**STORMWATER MANAGEMENT PLAN  
FOR  
STERLING RANCH EAST FILING NO. 6**

EPC STORMWATER REVIEW COMMENTS  
IN ORANGE BOXES WITH BLACK TEXT

**SP-24XX** **SP244**

STERLING RANCH EAST FILING NO. 6
EARLY GEC PLAN

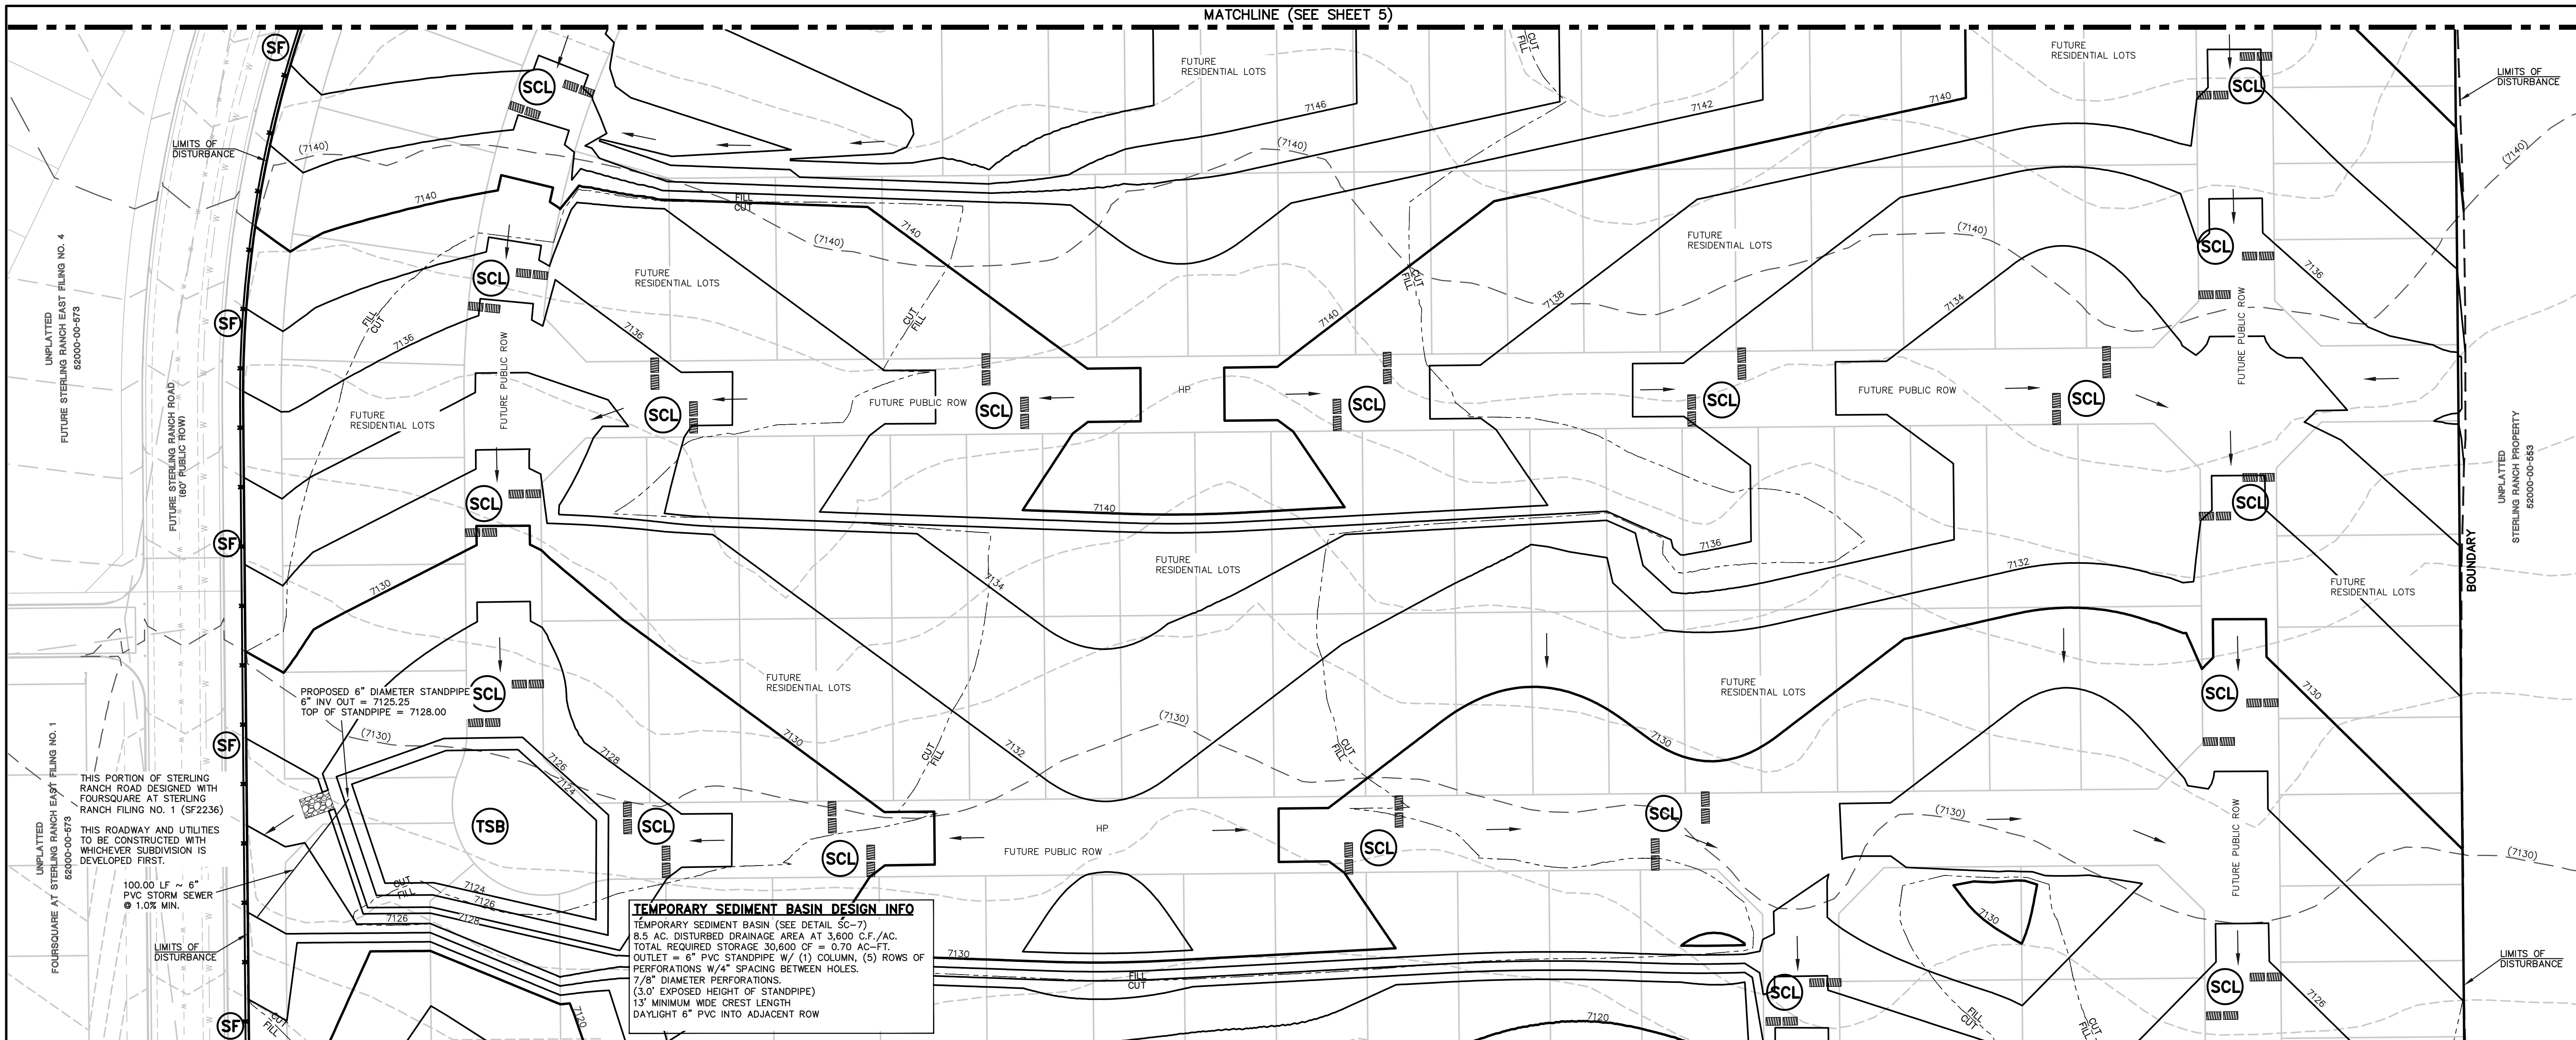
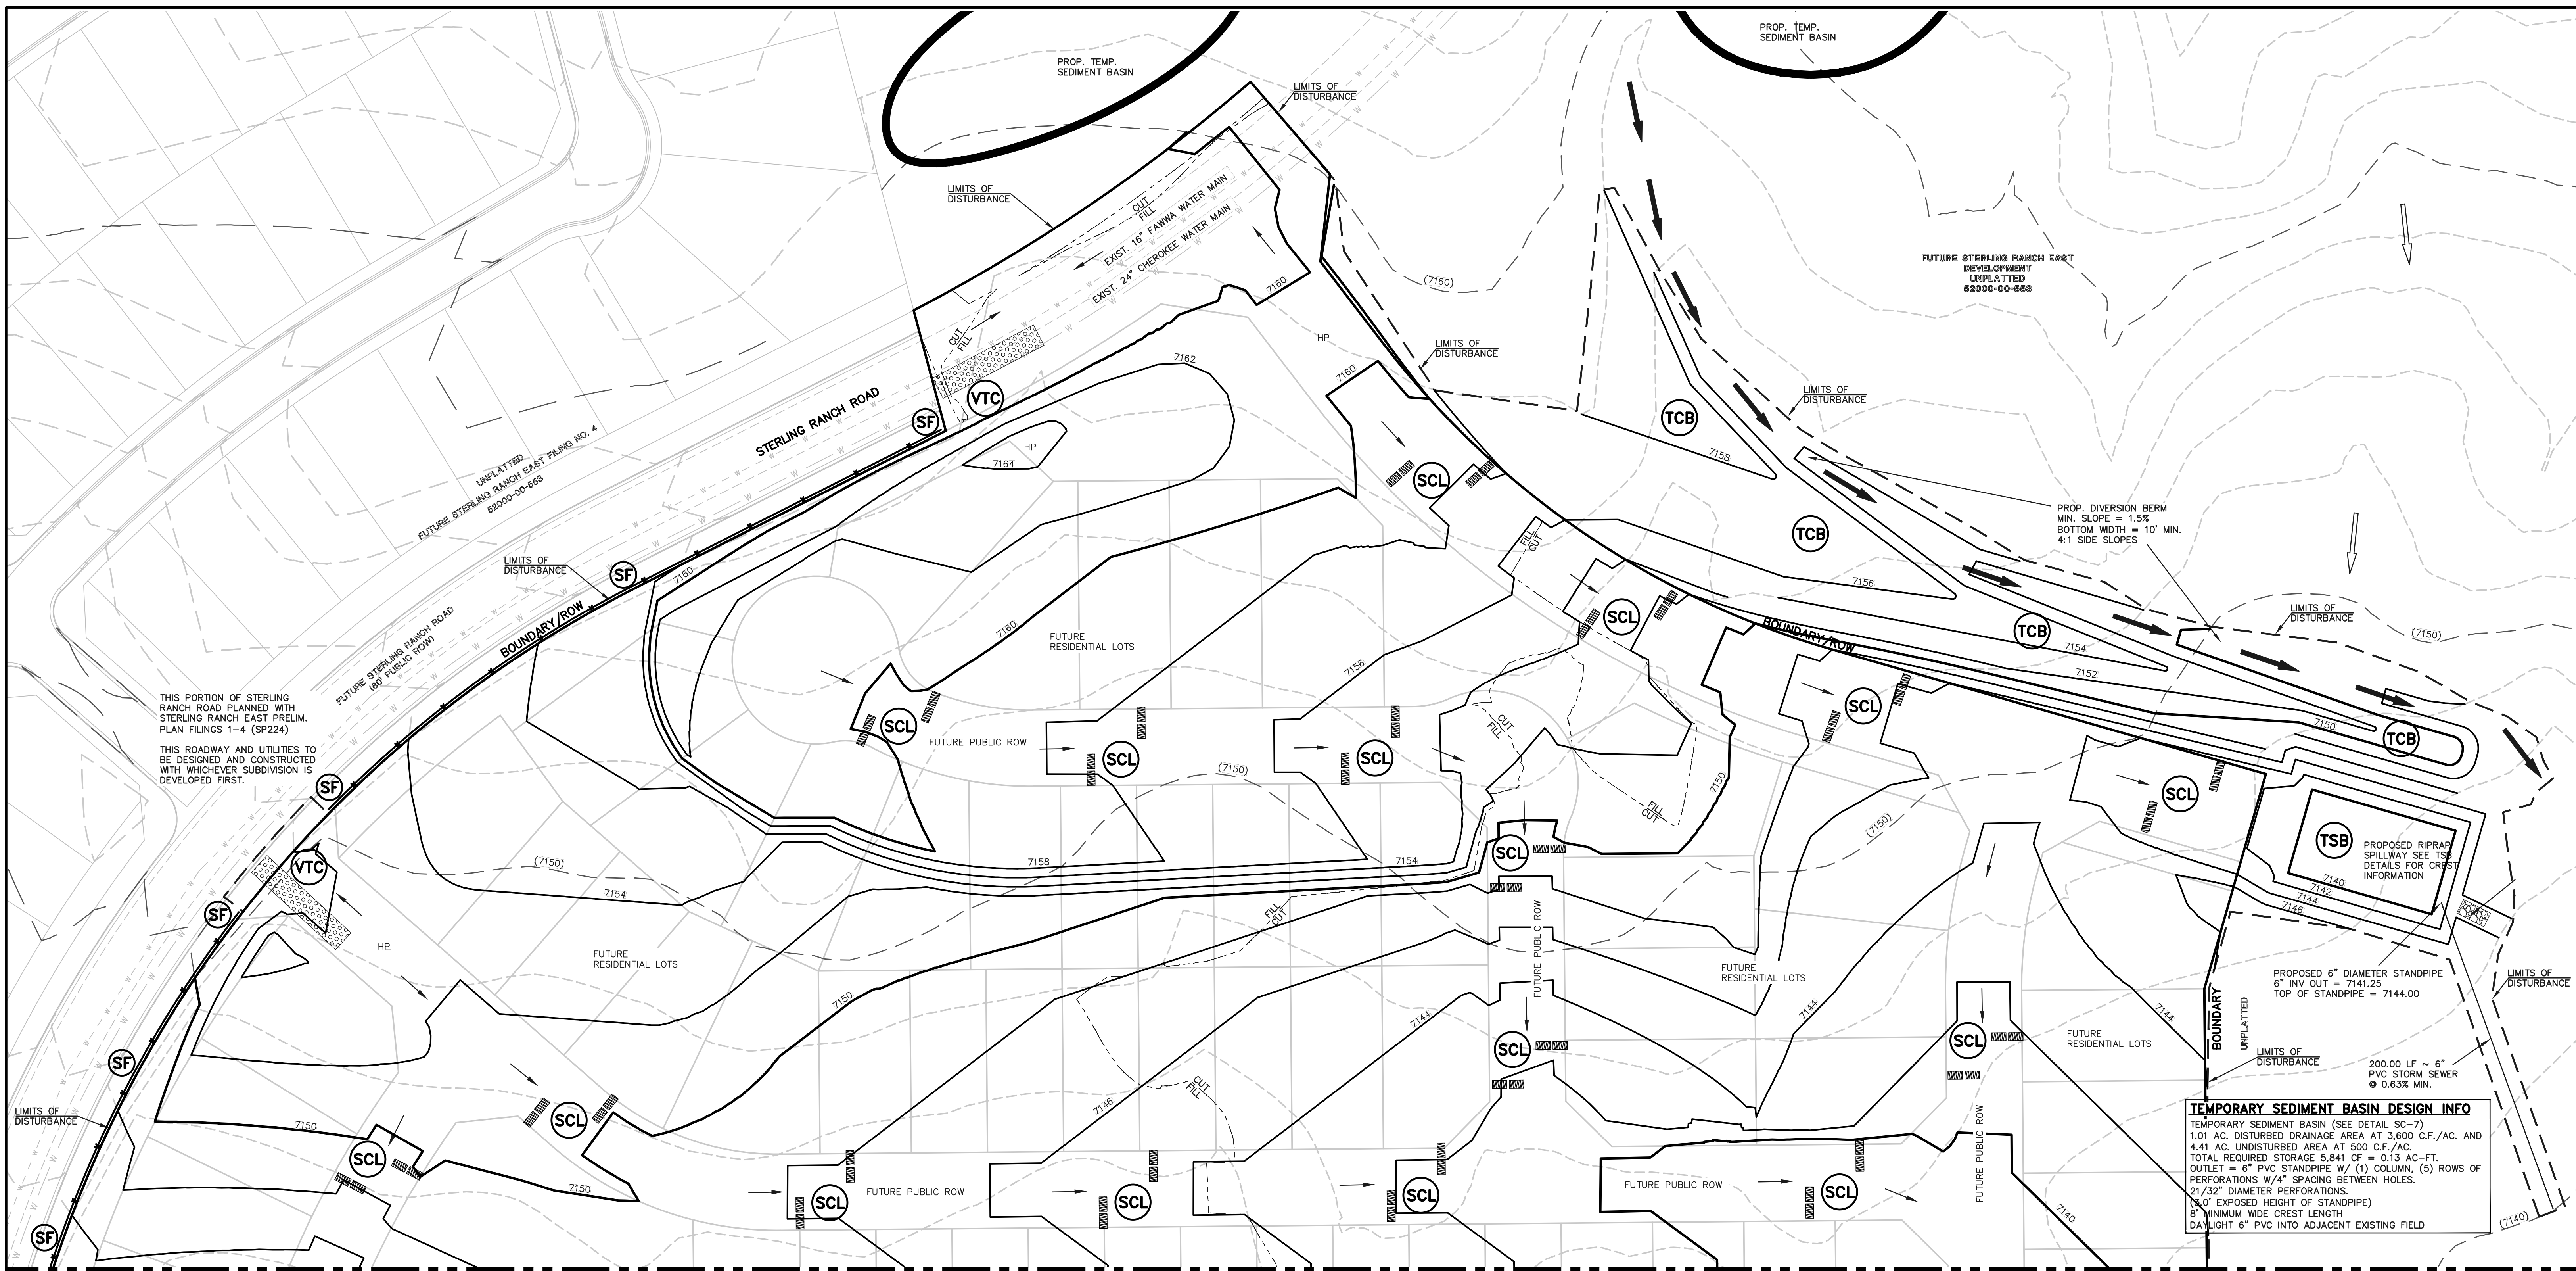
Item 18. Inlet Protection, Check Dams, and Temporary Compacted Berms are indicated on submitted GEC Plan; Update narrative description accordingly.
